An  
Coimisiún  
Pleanála

**Direction**  
**ABP-320327-24**

The submissions on this file and the Inspector's report were considered at a meeting held on 19/11/2025.

at Kippure Lodge and Holiday Village, Kippure Estate, Manor Kilbride, Blessington, County Wicklow is or is not development or is or is not exempted development:

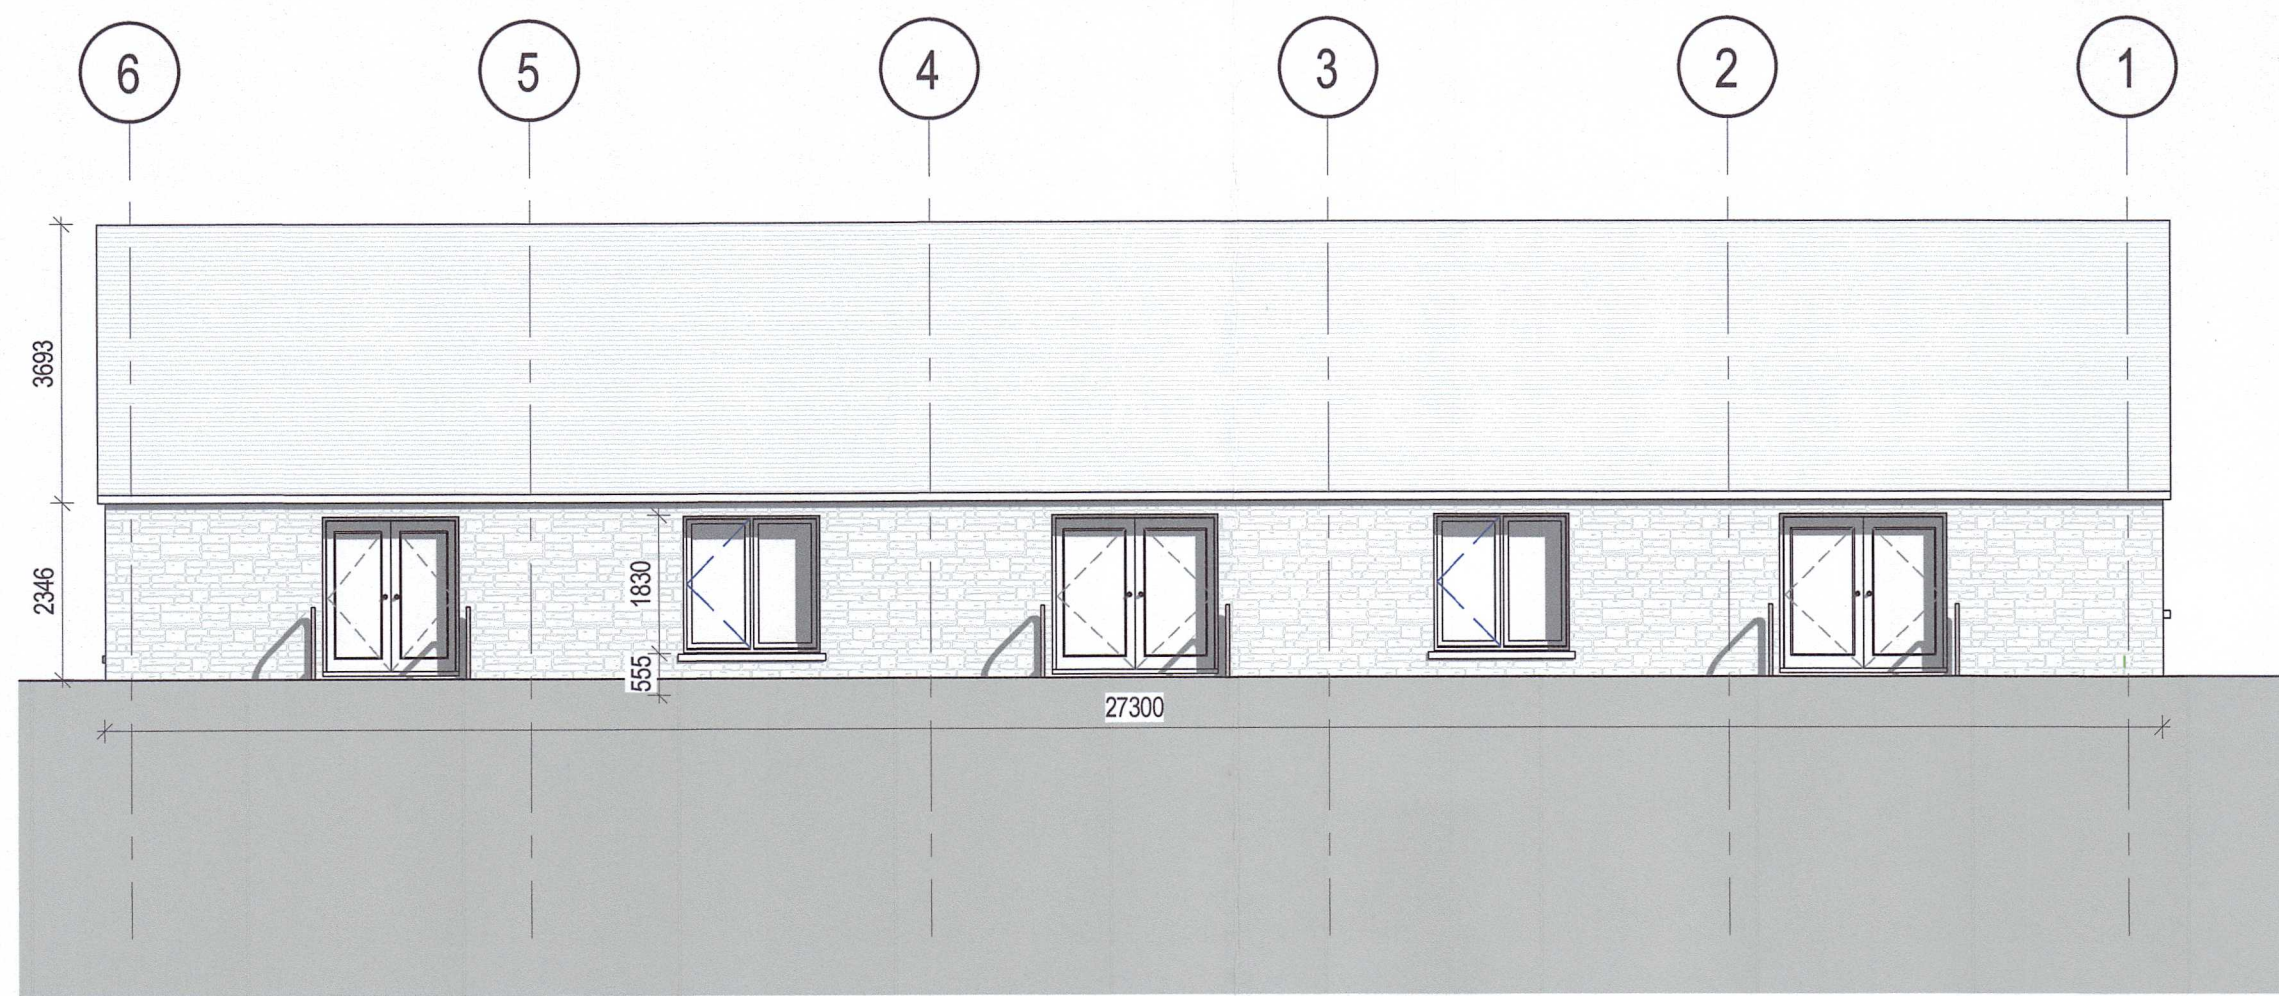
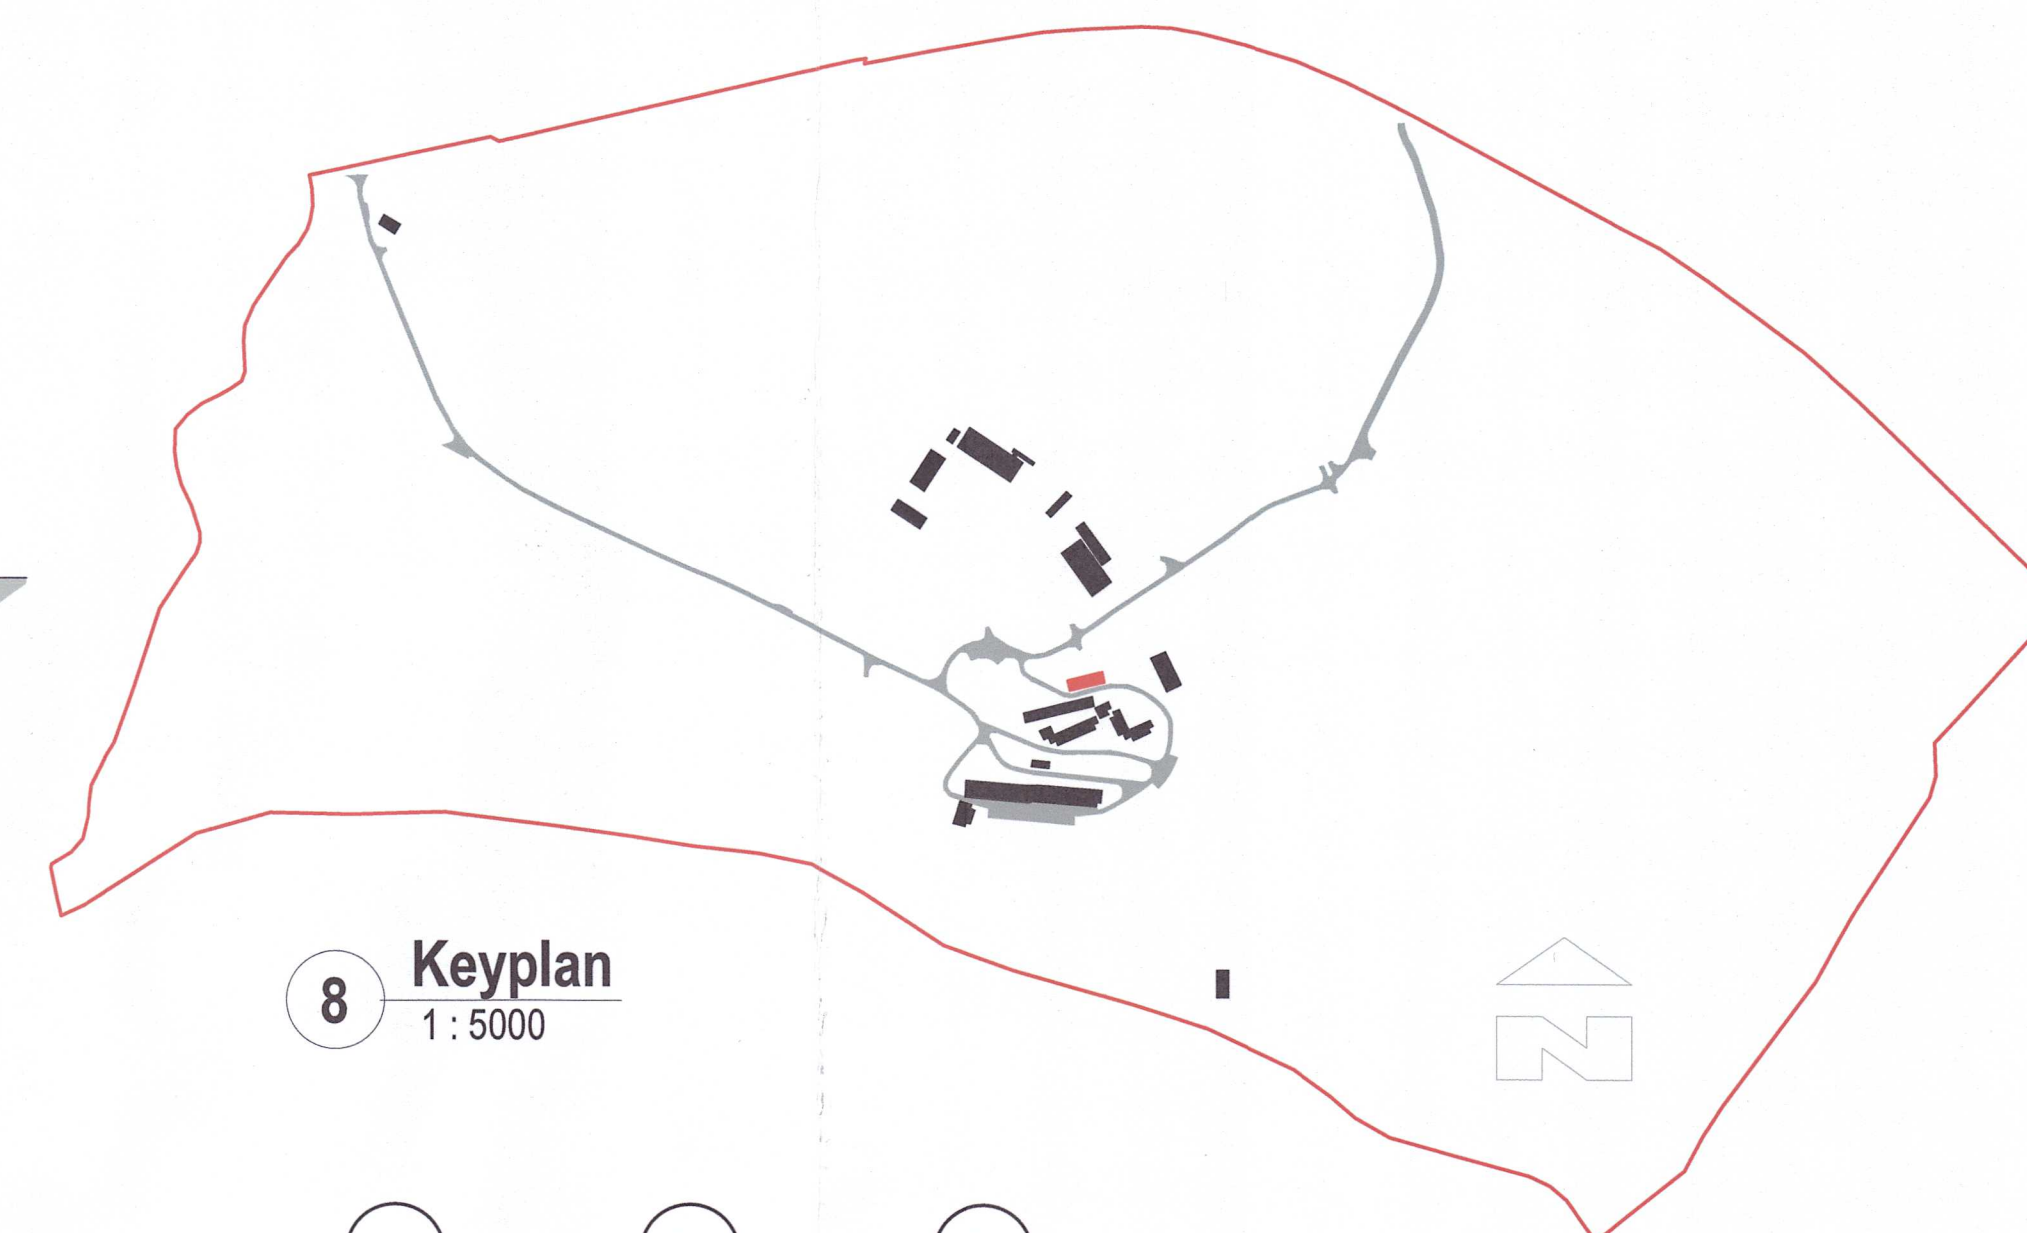
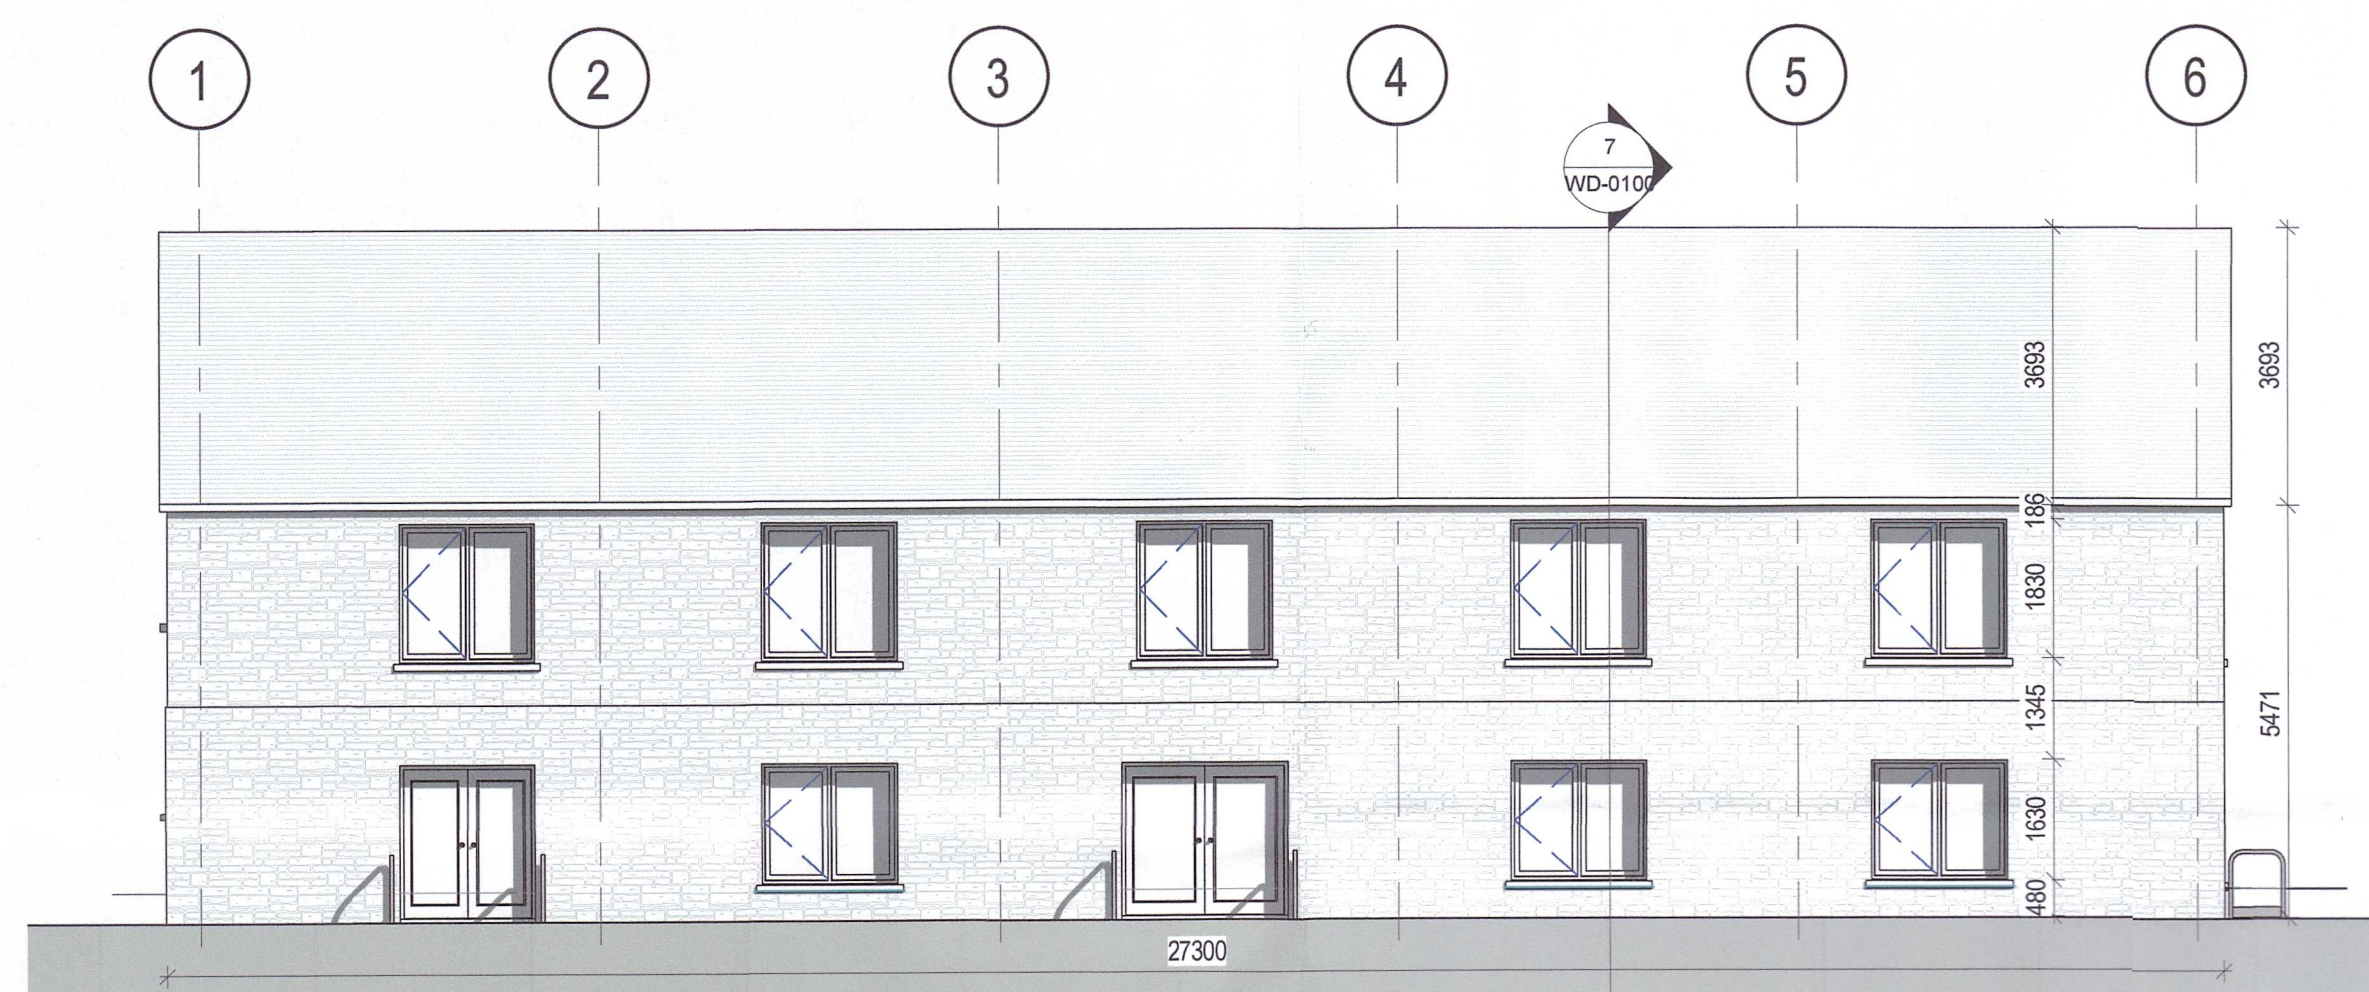
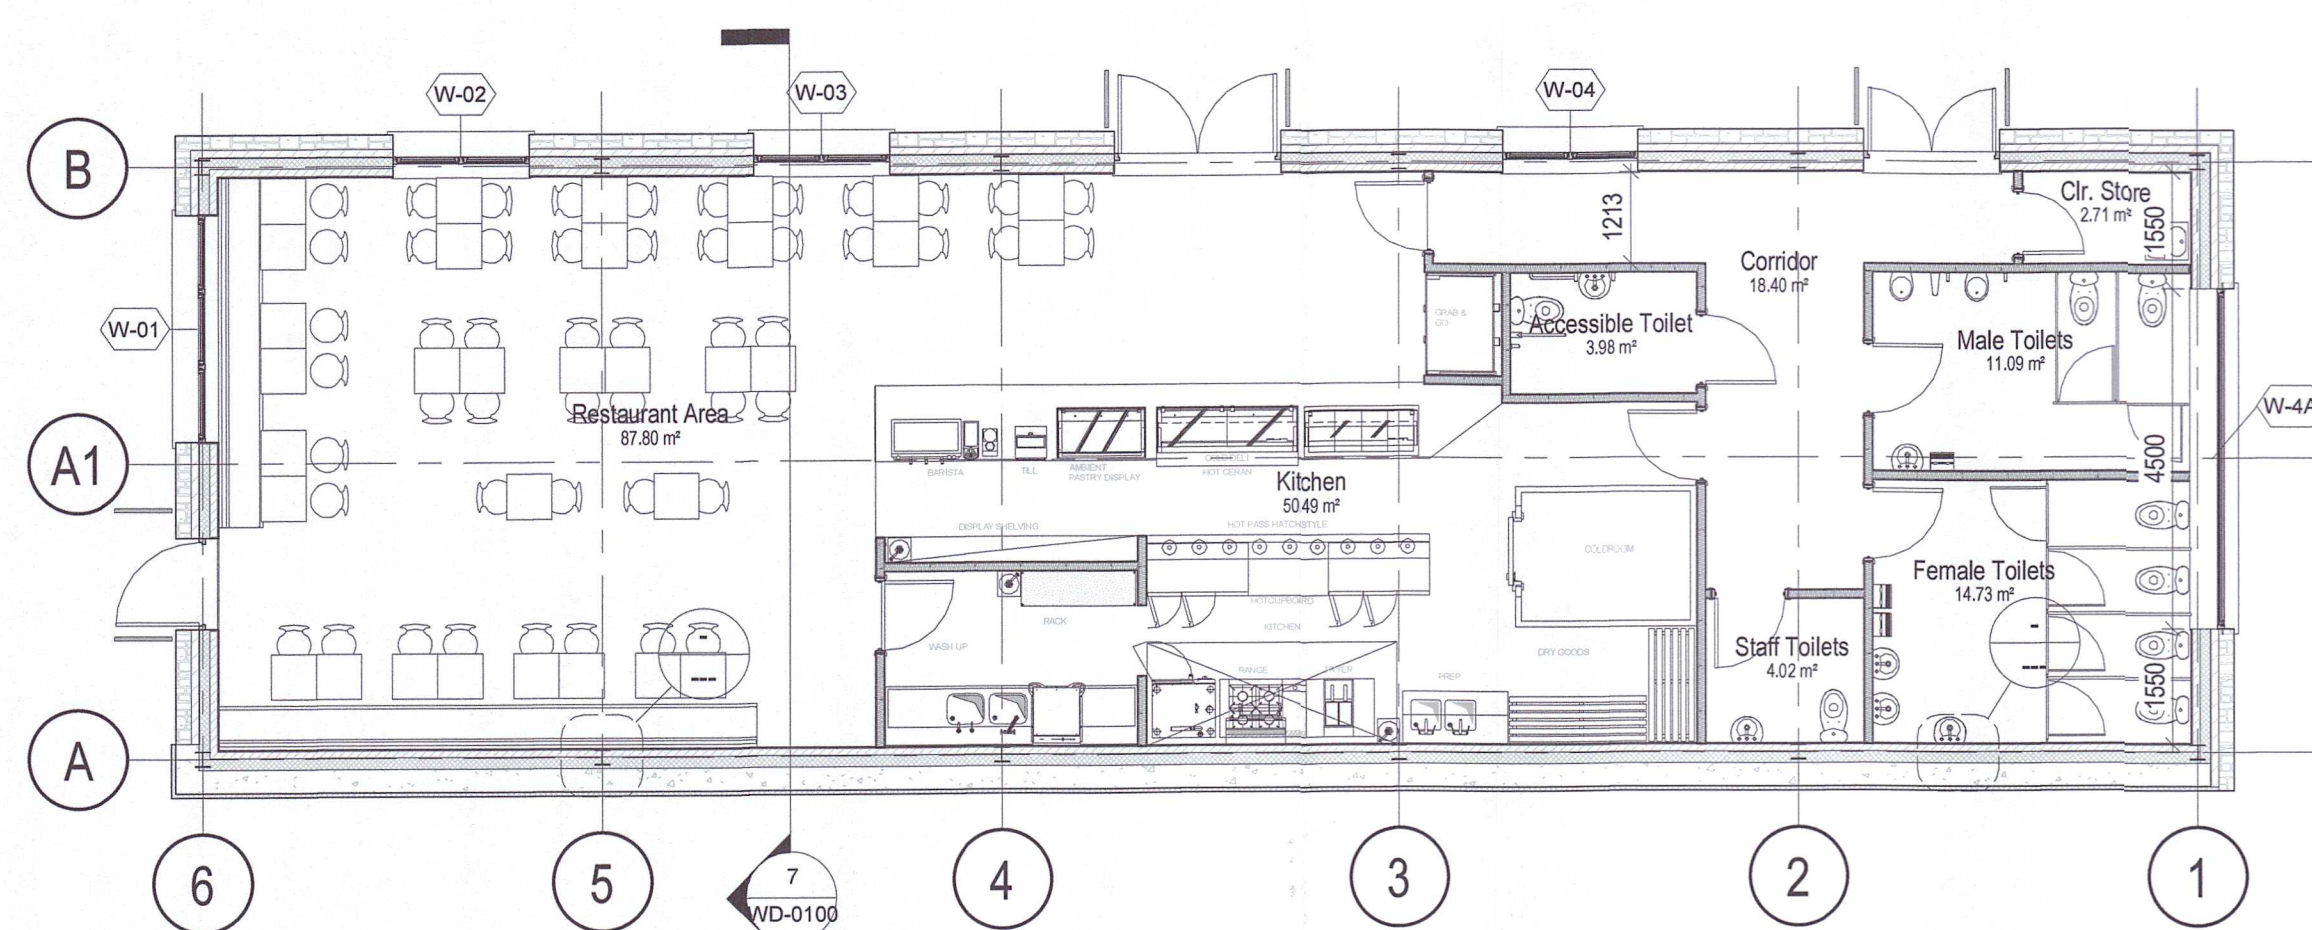
- (h) Structure Number 10: Having regard to the significant nature and scale of the works to the original structure 'Belfry' and the development approved under planning authority Register Reference 05/2792 the works do come within the scope of Section 4(1)(h) of the Planning and Development Act, 2000, as the works materially affects the external appearance of the structure so as to render its appearance inconsistent with the character of the structure. Therefore, the works do not constitute exempted development.
